Town & Country Planning Act 1990 (as amended)
Town and Country Planning (Development Management Procedure) (England) Order 2015
Application for approval of matters reserved by conditions imposed under Y/48/11 relating to
condition No. 9, 11, 12 & 13 - details of access from site to public highway, car parking spaces,
secure cycle parking & details of the proposed surface & foul water drainage
Lamb Inn Bilsham Road, Yapton,

Condition Number 12

Arun District Council have decided to **APPROVE details reserved by this condition** has been provided

17066-2001 D

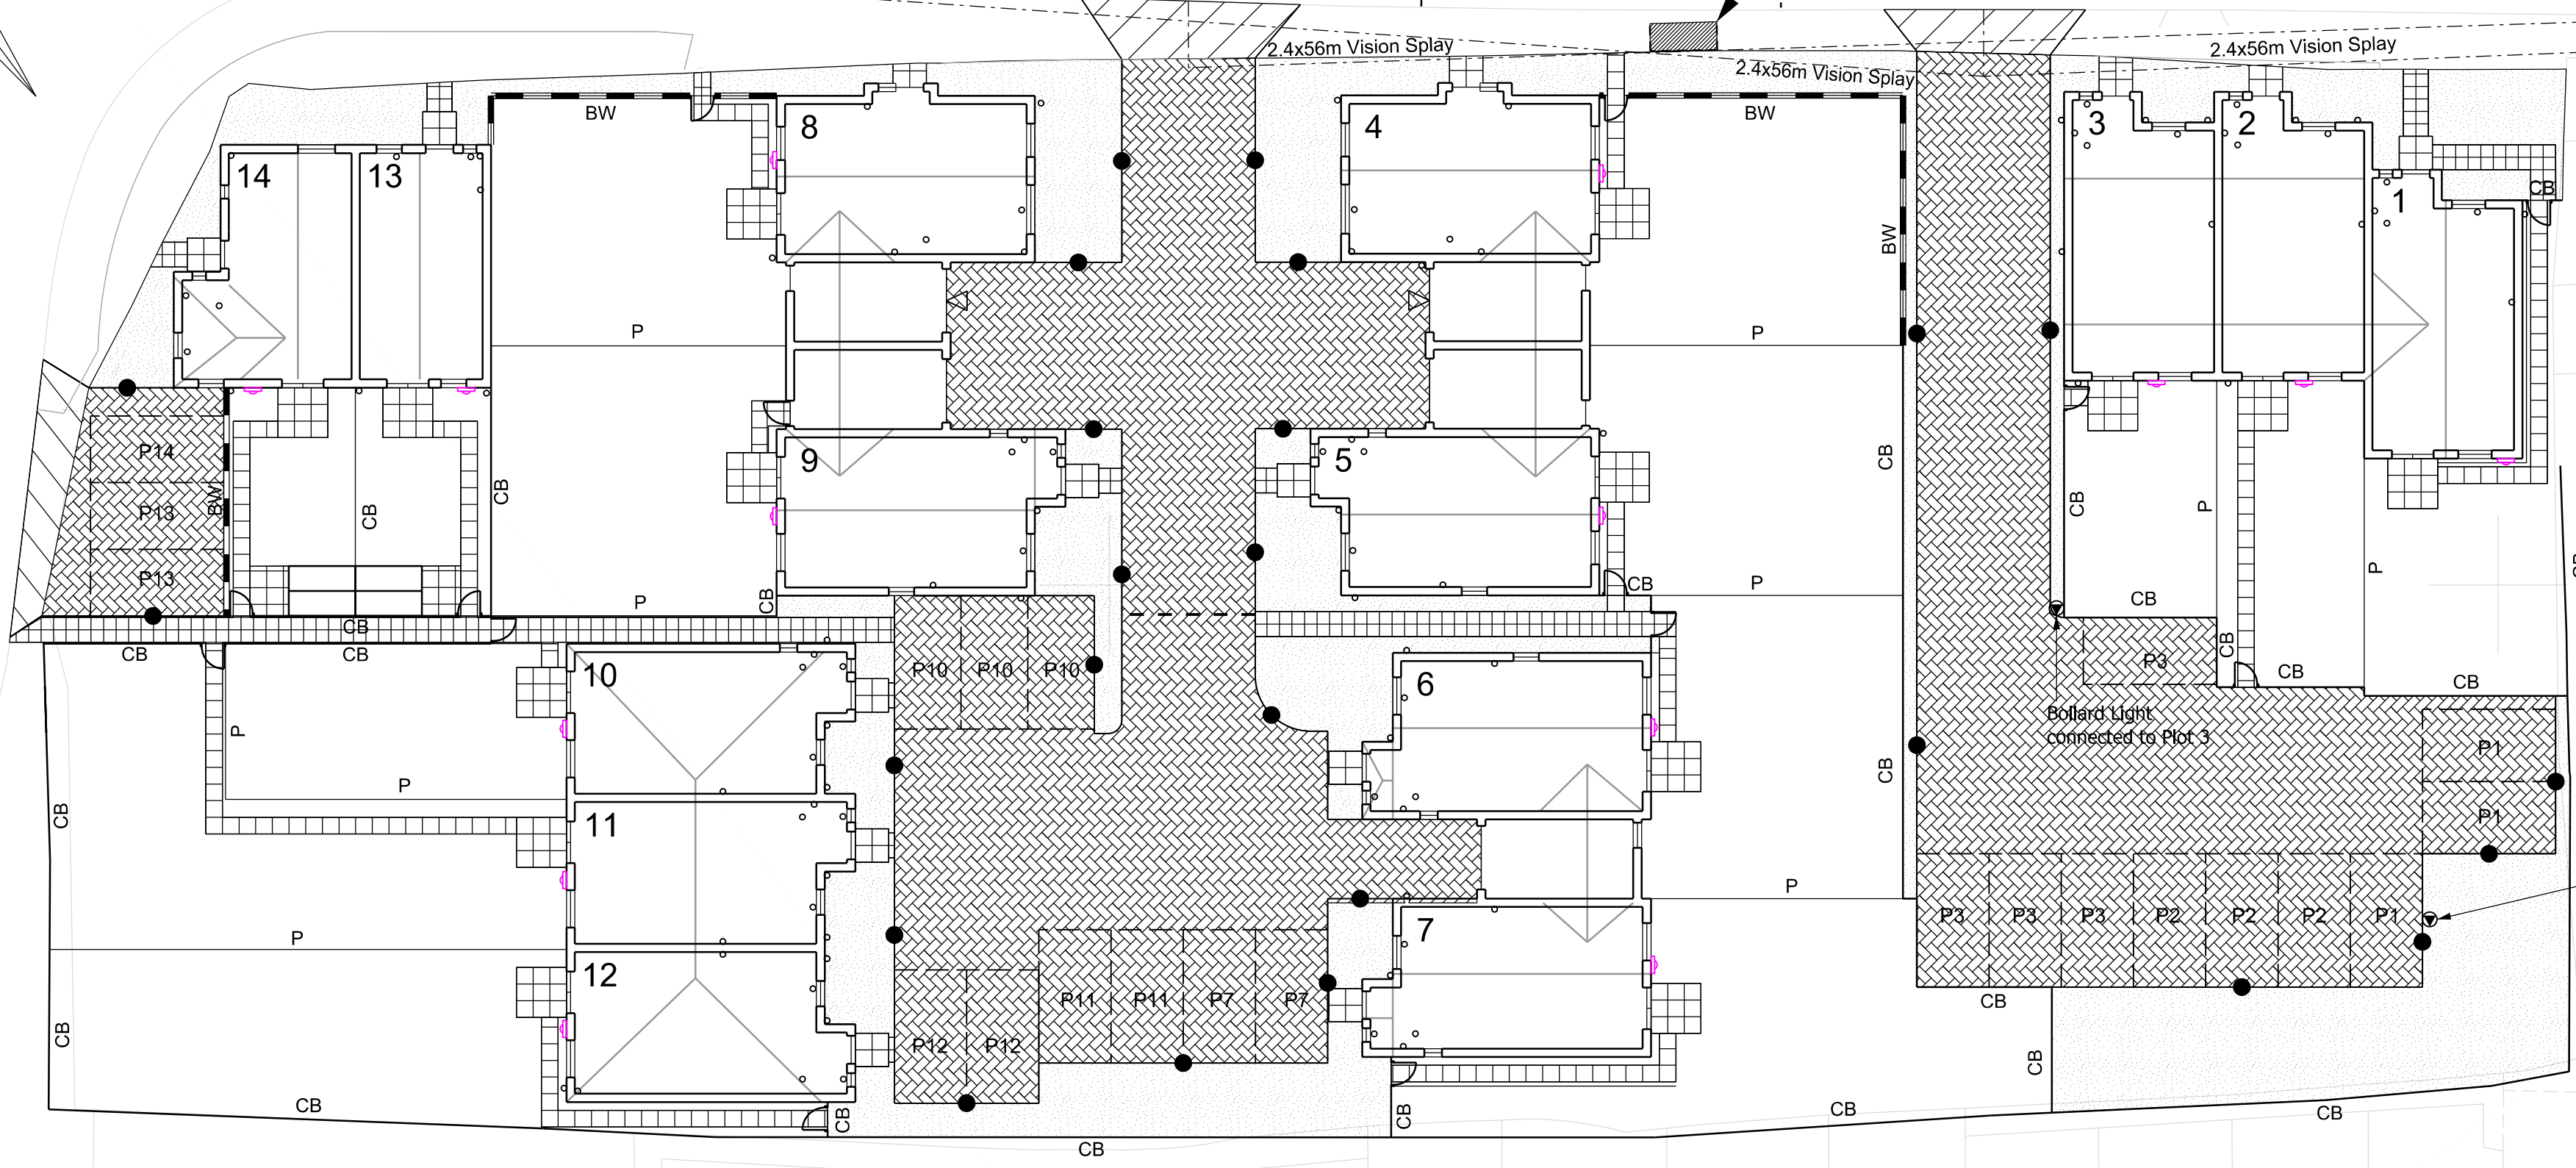
The details submitted in respect of the secure cycle parking, namely Drawing 17066-2001 Rev D "External Works" is considered to be satisfactory and satisfies the requirements of the condition.

The condition is therefore fully discharged insofar as the submission of details relates and on the understanding that the wall anchor cycle parking spaces will be implemented in accordance with the approved details and retained thereafter.

However, please also note that the Highway Authority recommends that shelter is provided for the ABUS parking as it will encourage greater use by residents and provide greater protection of bicycles from degradation caused by exposure to adverse weather conditions.
